Davis Ranch Subdivision
Master Traffic Impact Study
(LSC #S224640)
July 7, 2023

Add PCD File No. SKP232

Master Traffic Impact Study

Figure 2  
**Site Plan**

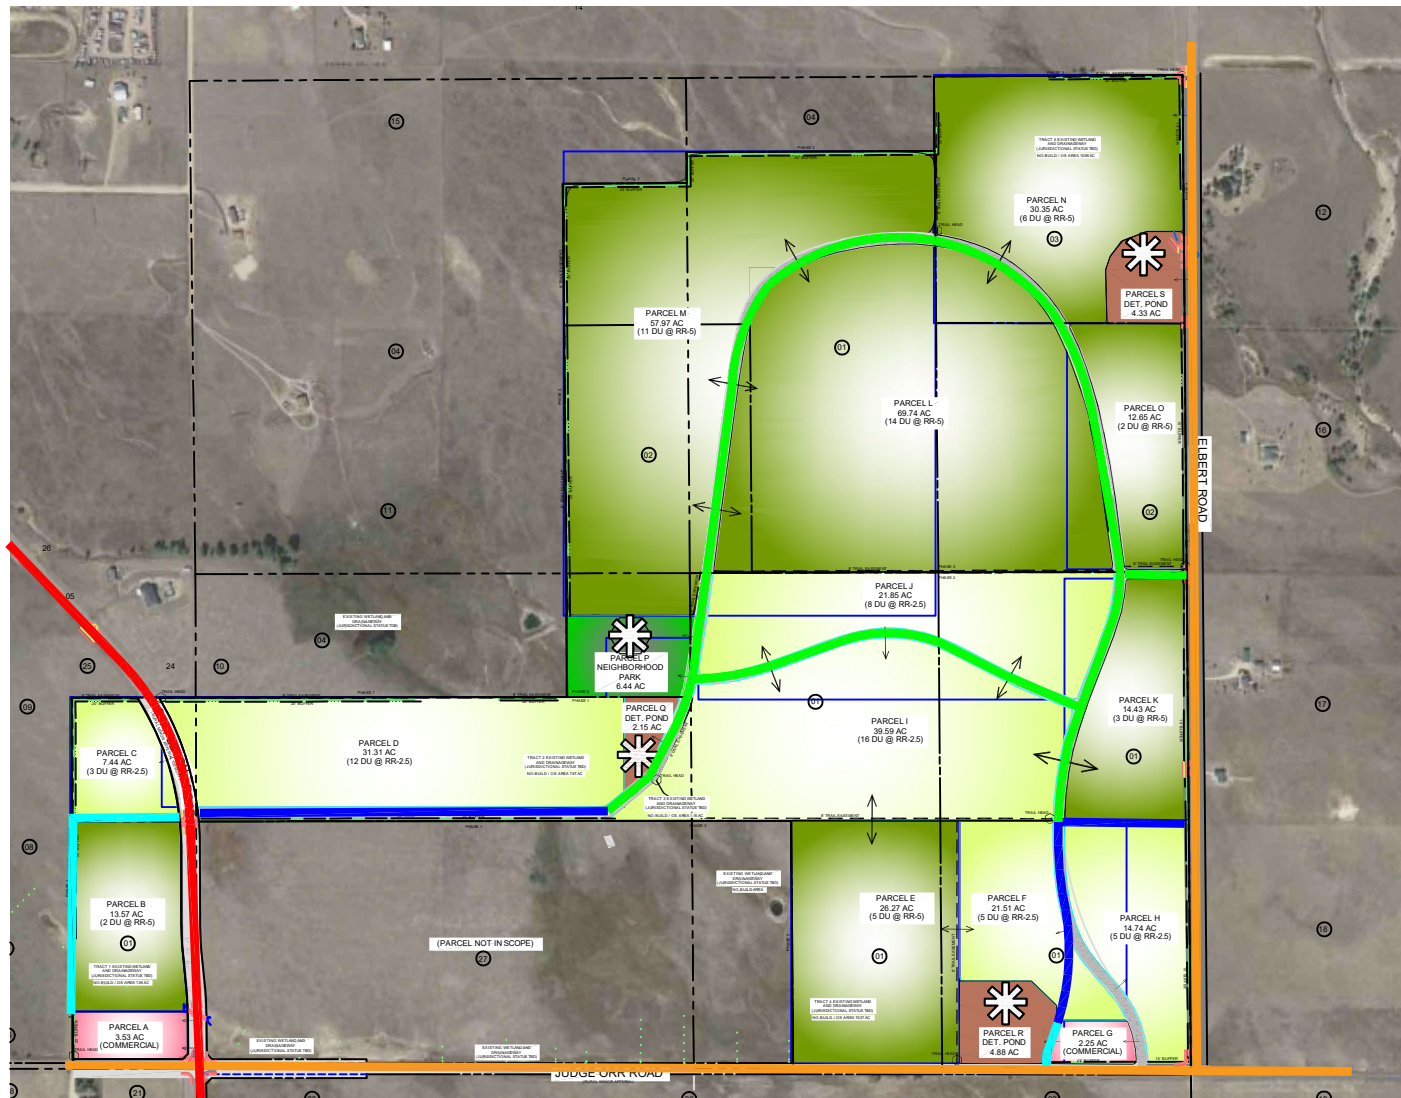
note shown on the sketch plan.
Please coordinate with the planning consultant so that the sketch plan and TIS are consistent

Please revise the traffic analysis as it was determined that no access would be allowed along Stapleton as 1/2 mile spacing is not met and access proposed is not identified on the Stapleton corridor plan.
